KITTITAS COUNTY

MEMORANDUM

TO: Community Development Services
FROM: Taylor Gustafson, Environmental/Transportation Planner
DATE: July 23, 2019
SUBJECT: Public Works Review of DV-19-00001 Marian Meadows

AIRPORT LAND USE PLAN

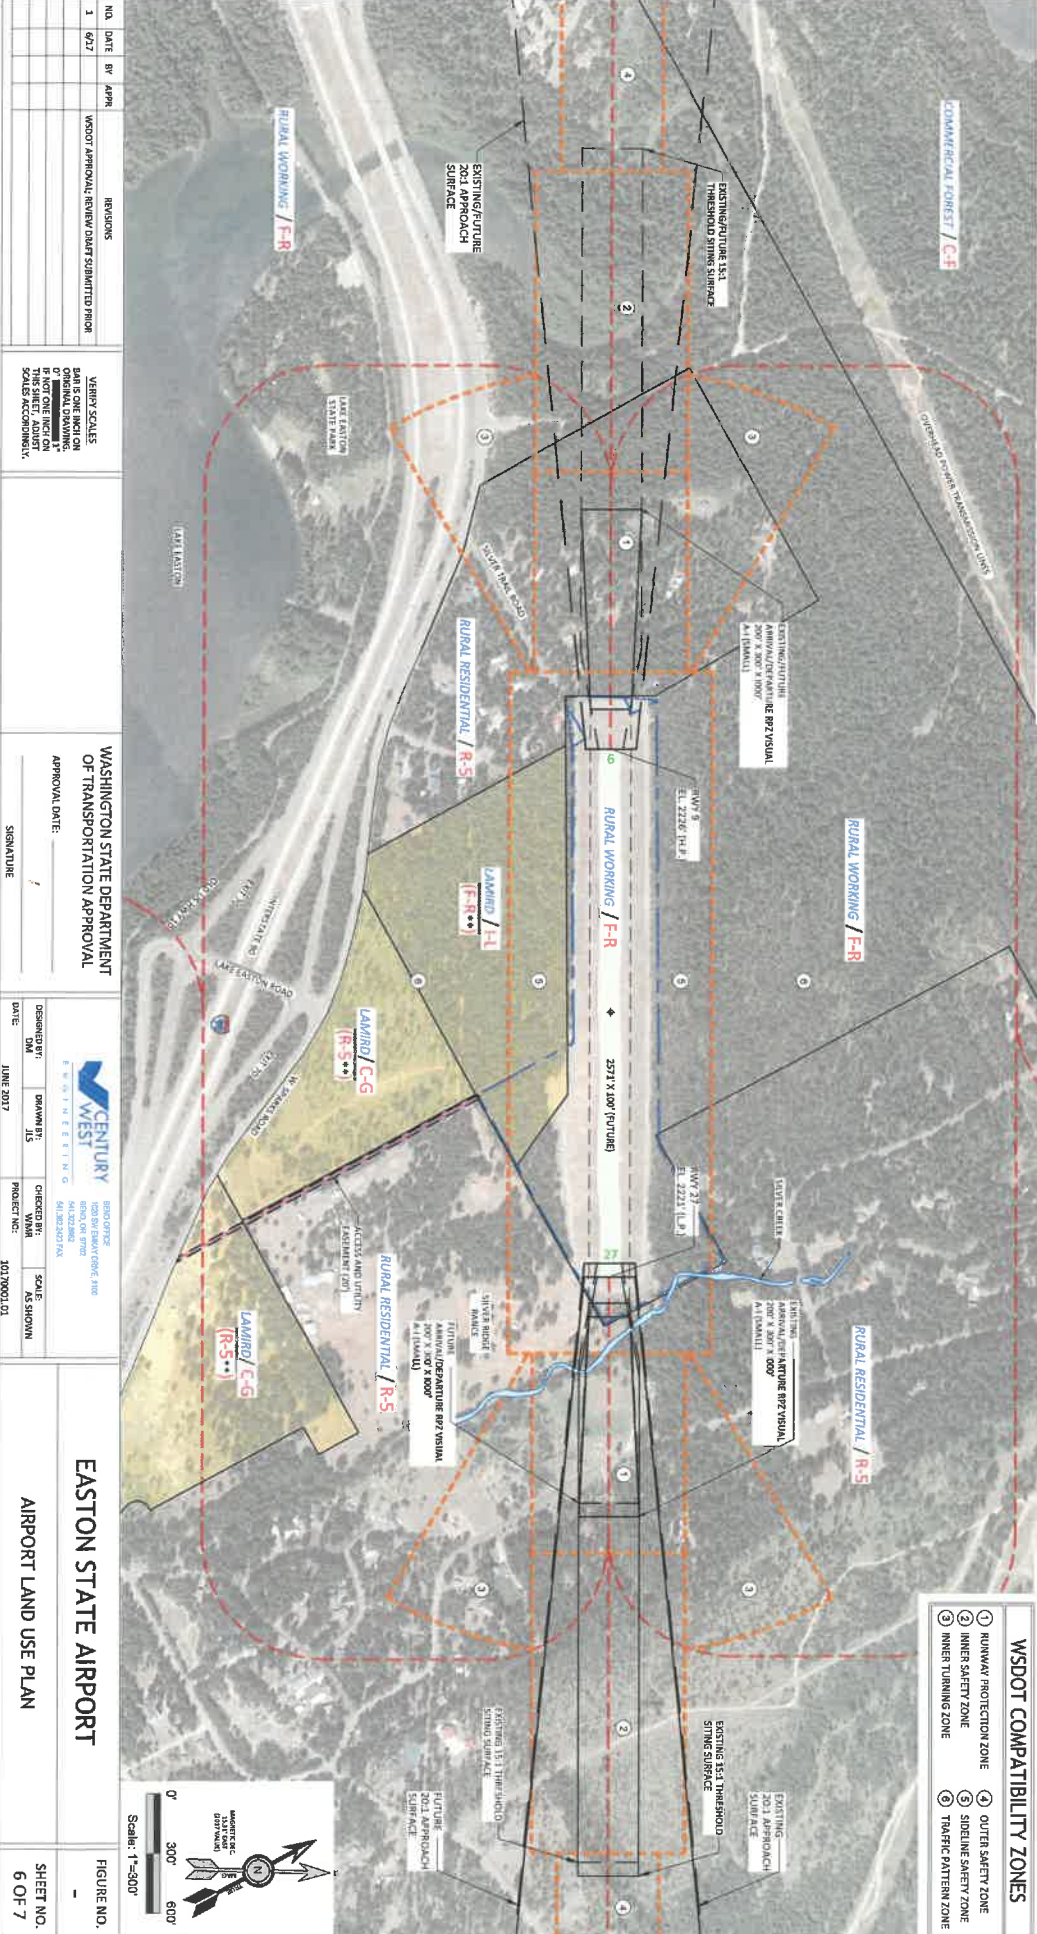
7. The Airport Safety Zone Map is unclear. Provide a legend defining each color.
8. Phasing is unclear. Clarify the specific phases in numeric order.
9. How can the water tank construction be independent of Marian Meadows development as it is a critical part of the development's infrastructure? Please explain.
